Ribble Valley Borough Council
Council Offices
Church Walk,
Clitheroe
Lancashire
BB7 2RA

Phone: 0300 123 6780
Email: developeras@lancashire.gov.uk
Your ref: 3/2026/0458
Our ref: 3/2026/0458/HDC/KW
Date: 14 August 2026

Location: The Old Printworks 4a and 6a Back York Street Clitheroe BB7 1LT
Proposal: Proposed partial demolition of existing building and change of use from former printing works (Class B1(c)) to form 2No. residential apartments (Class C3) with associated external works.
Grid Ref: 374496 441958

Proposed Ground Floor
1:100

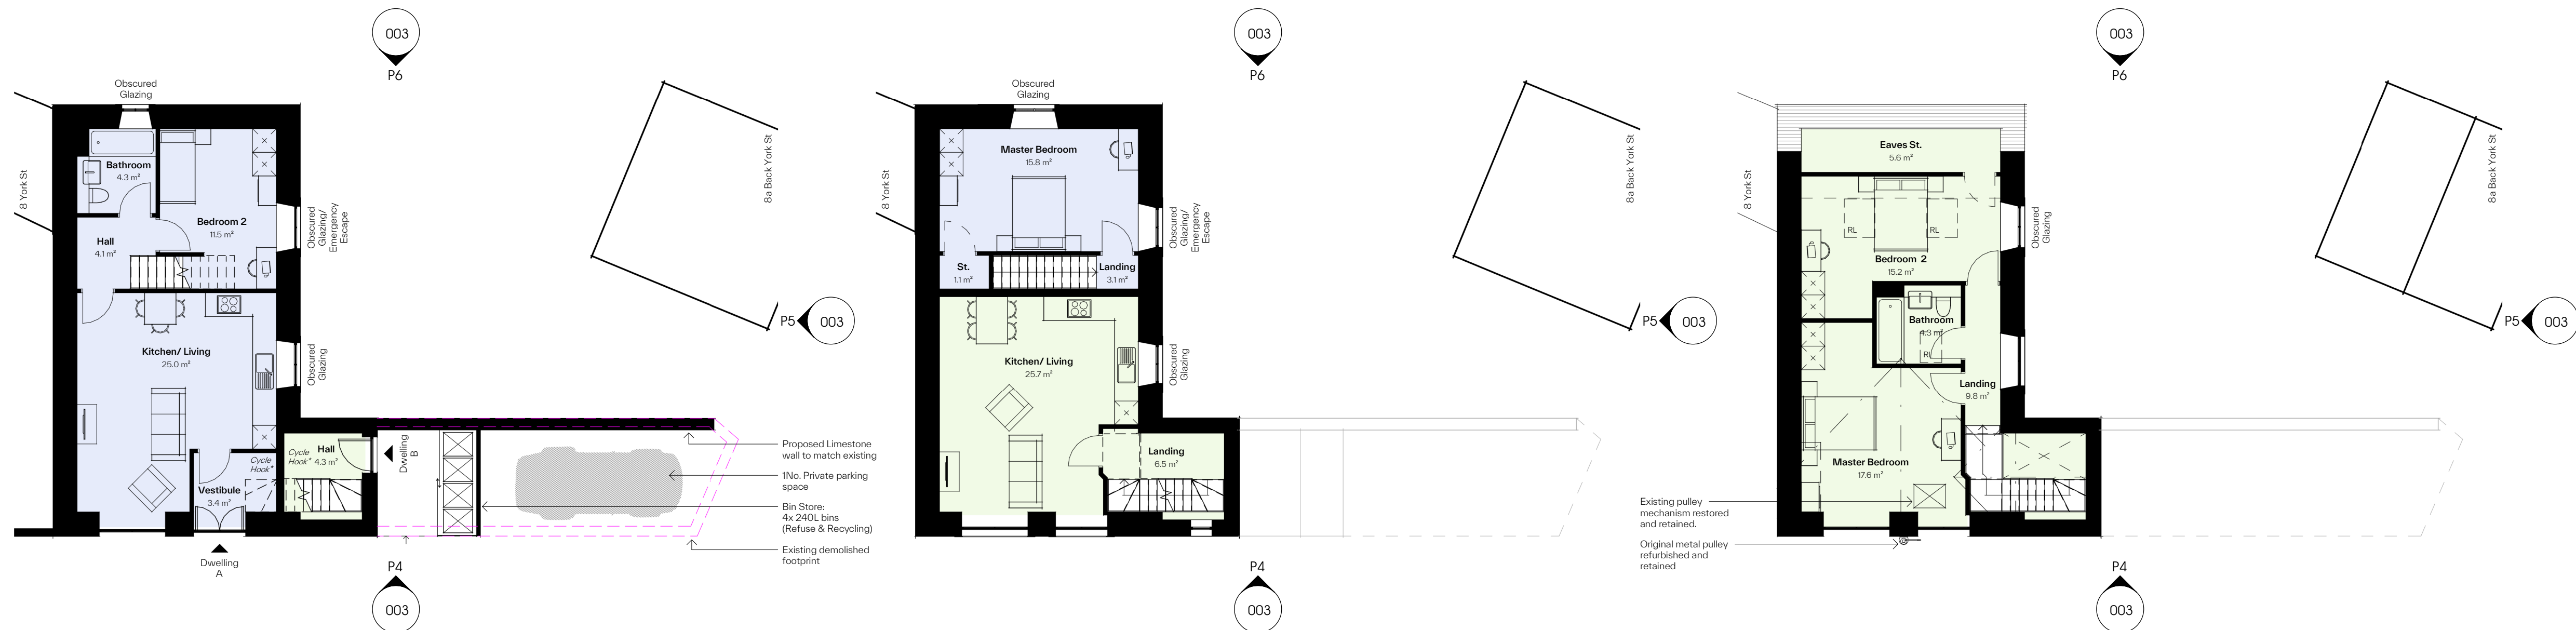
The LHAs are aware that one parking space is proposed within the site. This does not comply with the LHAs parking guidance as defined in the Joint Lancashire Structure Plan, which requires the site to provide a minimum of 2 car parking spaces per 2 bedroom dwelling. Despite this, the LHA will accept the shortfall in parking at the site. This is because the site is located in a sustainable location in the centre of Clitheroe.

It is understood a cycle storage hook is provided within the entranceway of each dwelling to encourage and promote sustainable transport means.
